**Pemulwuy Mixed Used Development (MP11_0093-Mod-3)
Response to Submissions**

I refer to the request to modify the project approval for the Pemulwuy mixed-use development, Redfern, to make minor internal and external amendments to Precinct 2 (MP11_0093 MOD 3).

4 Caroline Lane
1 : 200

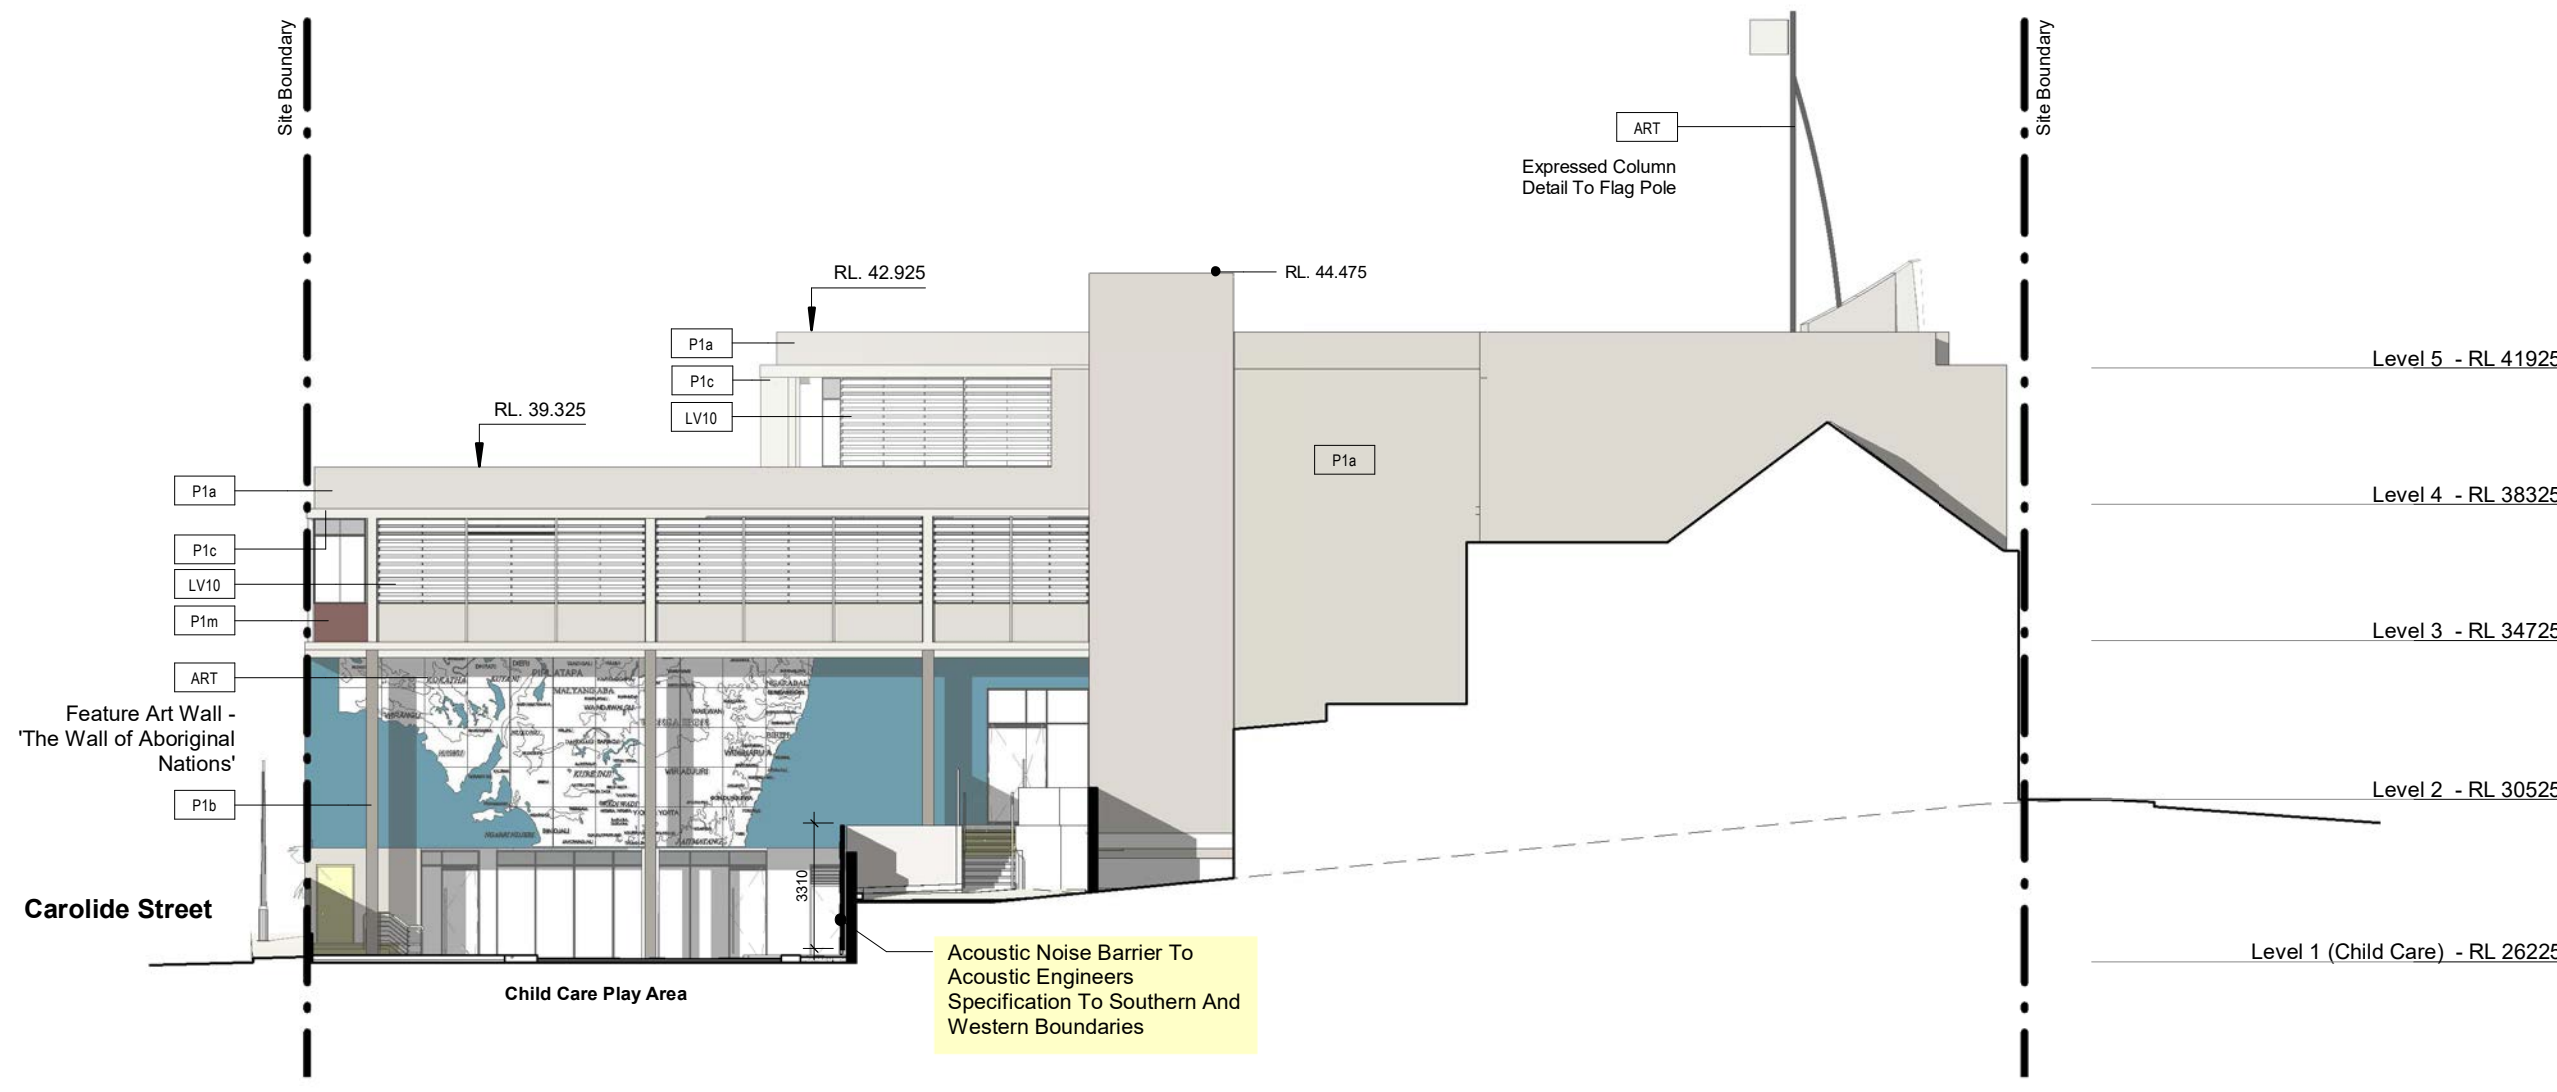
- provide further details of the proposed acoustic barrier to the southern and western elevations of the outdoor play area, including the extent of the barrier, height, materials and design to ensure a high quality appearance to the laneway
- provide an assessment of the noise and vibration impacts of the proposed plant room on level 2 on neighbouring properties and any mitigation measures required. Should impacts not be mitigated to an acceptable level, an alternate location may be required
- provide additional information in relation to the relocated waste management rooms and encroachments into the public domain, in response to the concerns raised in Council's submission.
